FISHERS CANYON CREEK CHANNEL IMPROVEMENT PLANS

FISHERS CANYON APARTMENTS IS A MULTI-FAMILY RESIDENTIAL DEVELOPMENT THAT PROPOSES 336 DWELLING UNITS ALONG THE FISHERS CANYON CREEK CORRIDOR. THE PROJECT EMBRACES FISHERS CANYON CREEK TRIBUTARY TO THE WEST AND FISHERS CANYON CREEK TO THE NORTH WITH CREEK IMPROVEMENTS. COUNTY PROJECT NUMBER #CDR246.

FISHERS CANYON CREEK
CHANNEL IMPROVEMENT PLANS
EL PASO COUNTY, COLORADO
COVER

TRIBUTARY - PLAN VIEW
STA. 61+05 TO 58+00

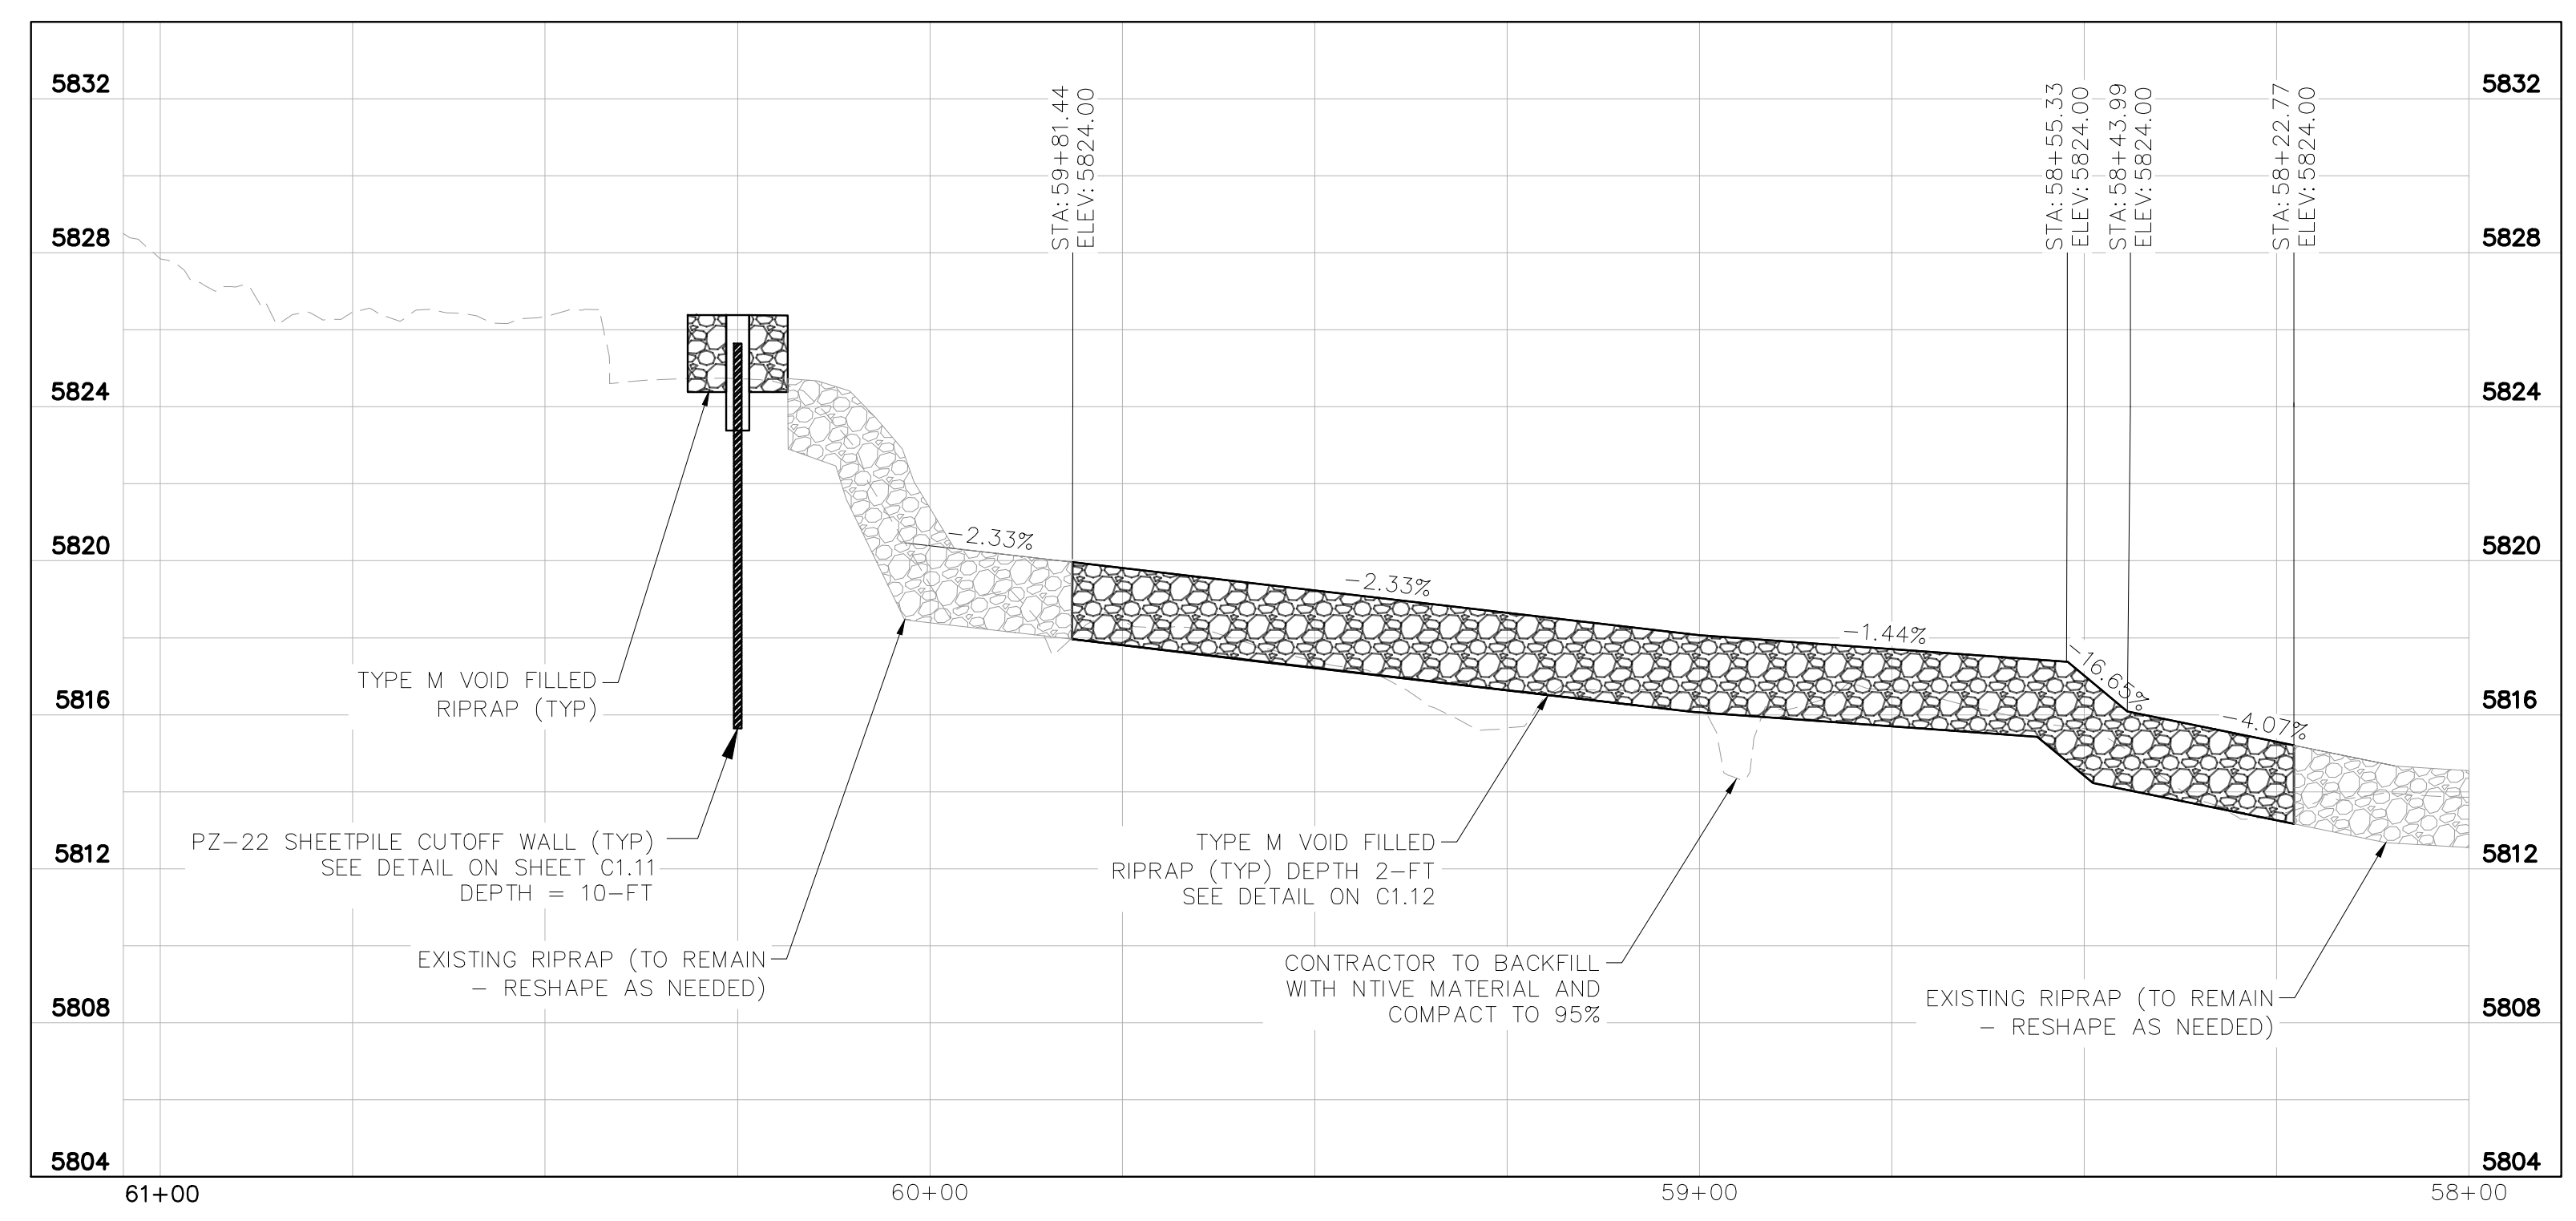
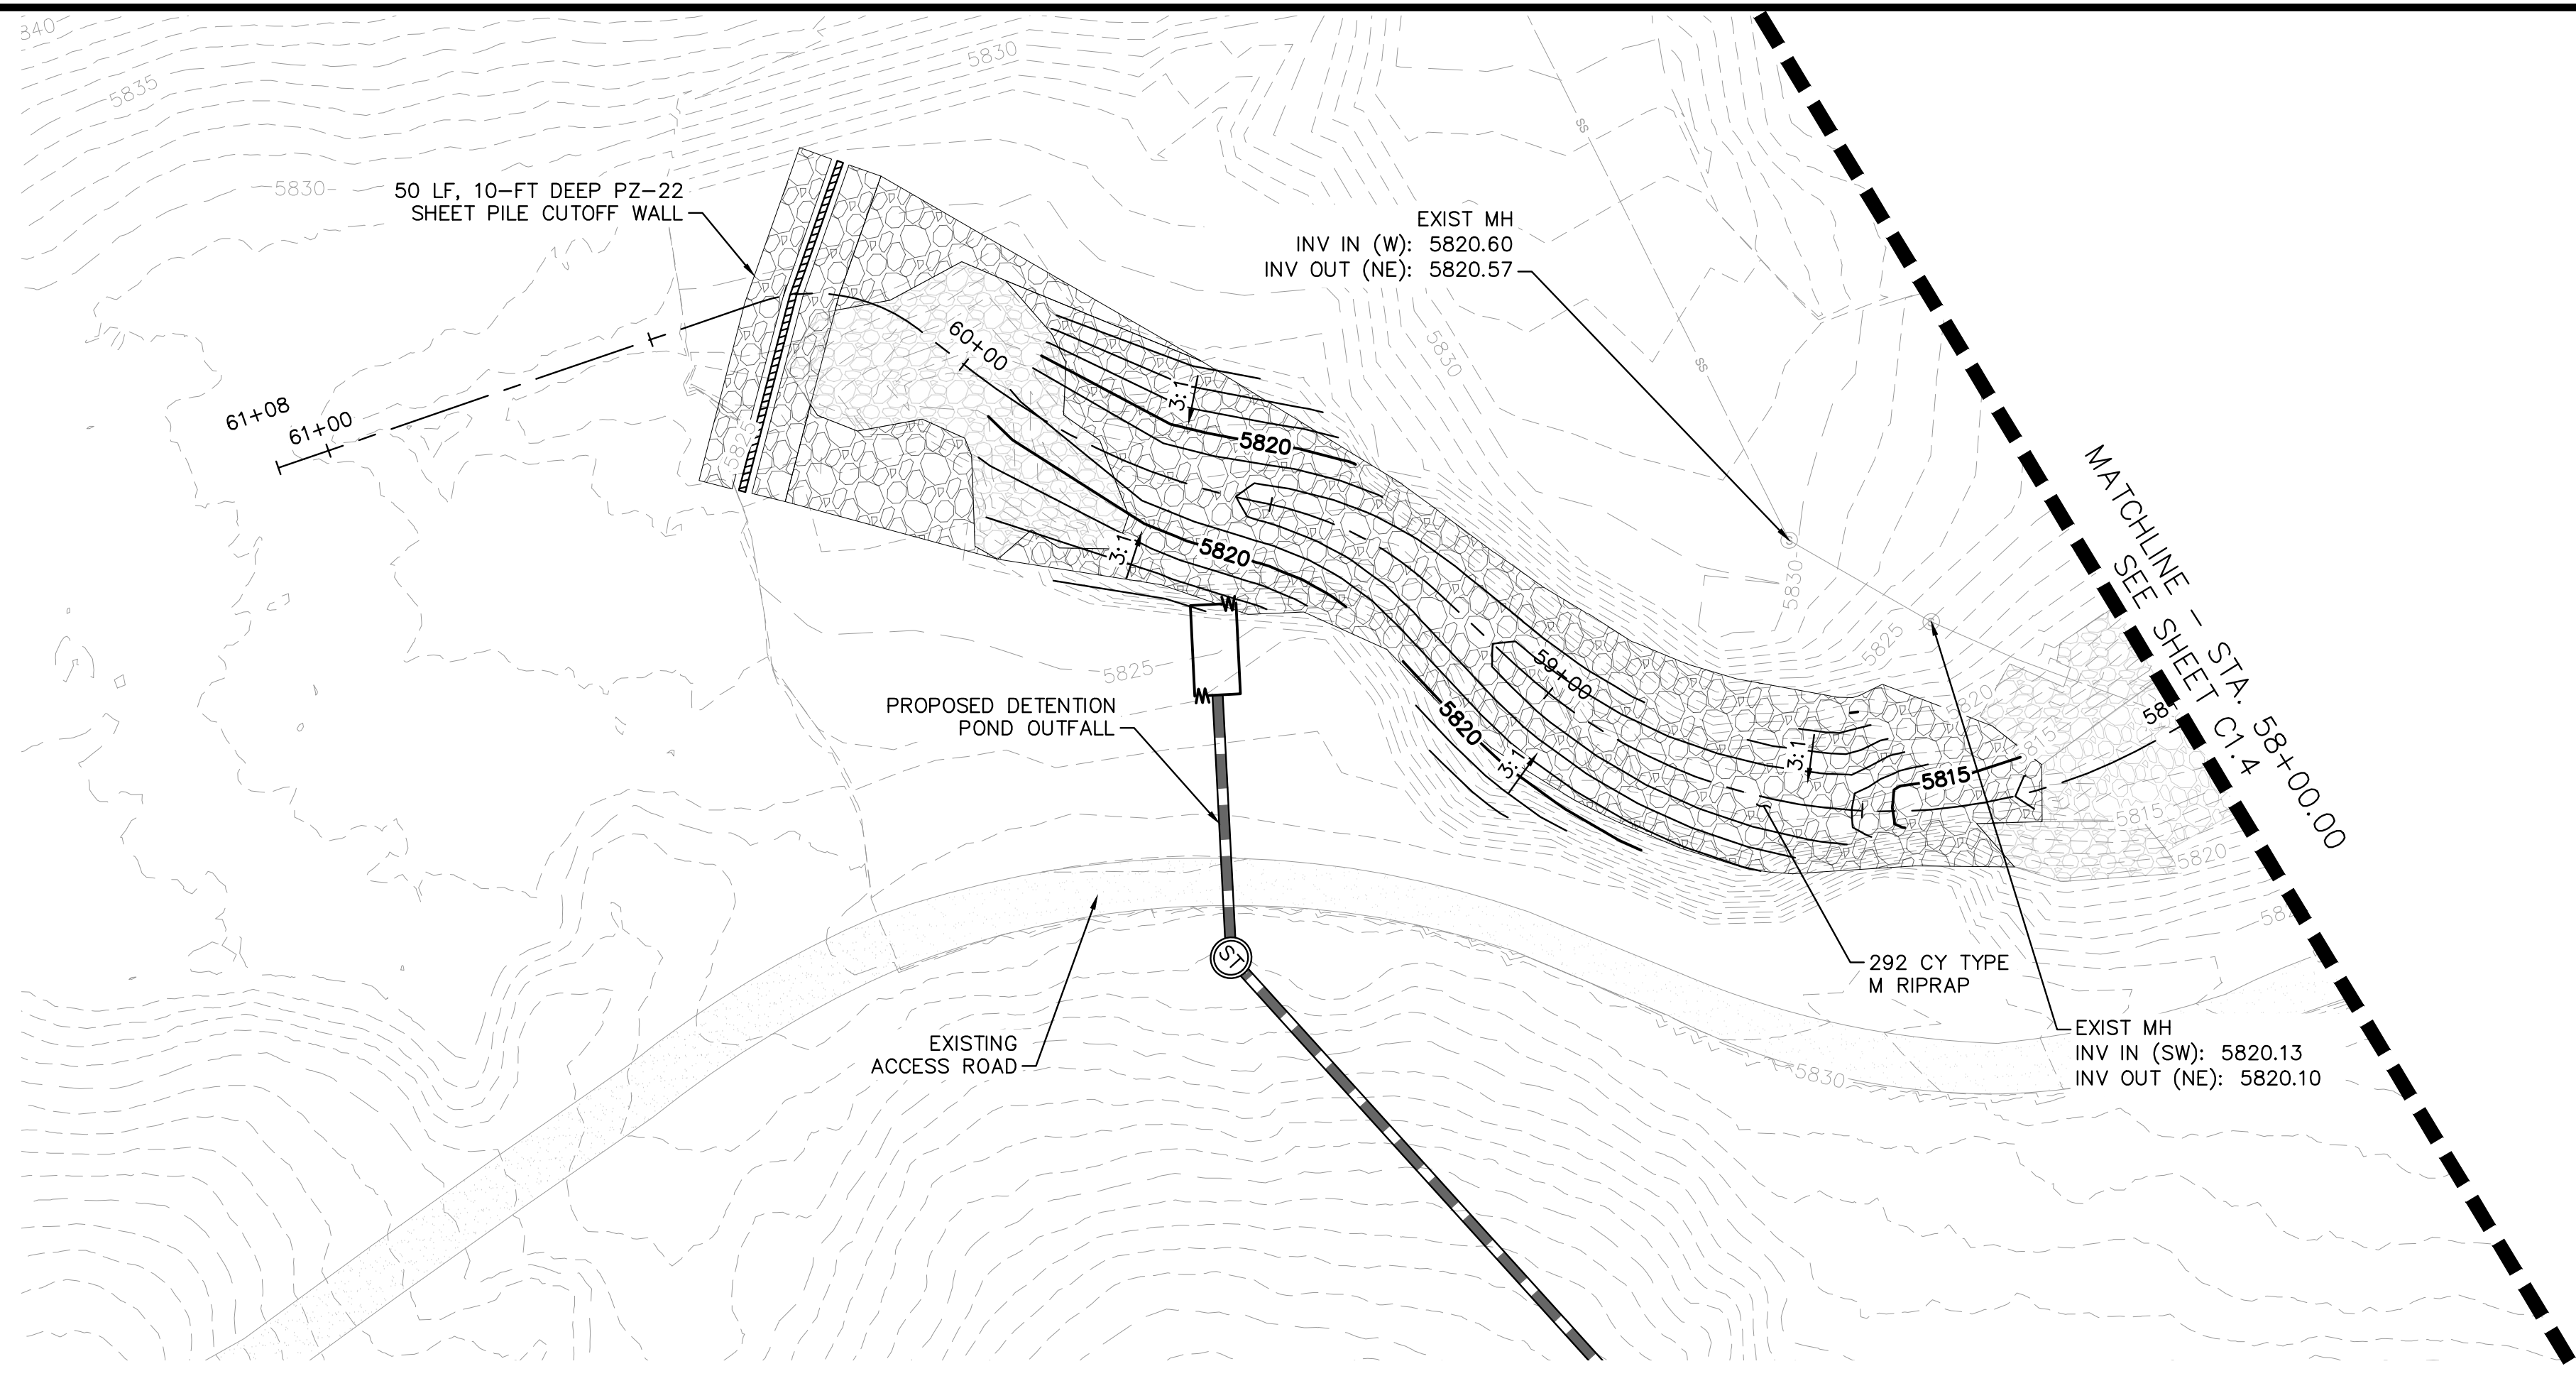
show the pond outfall
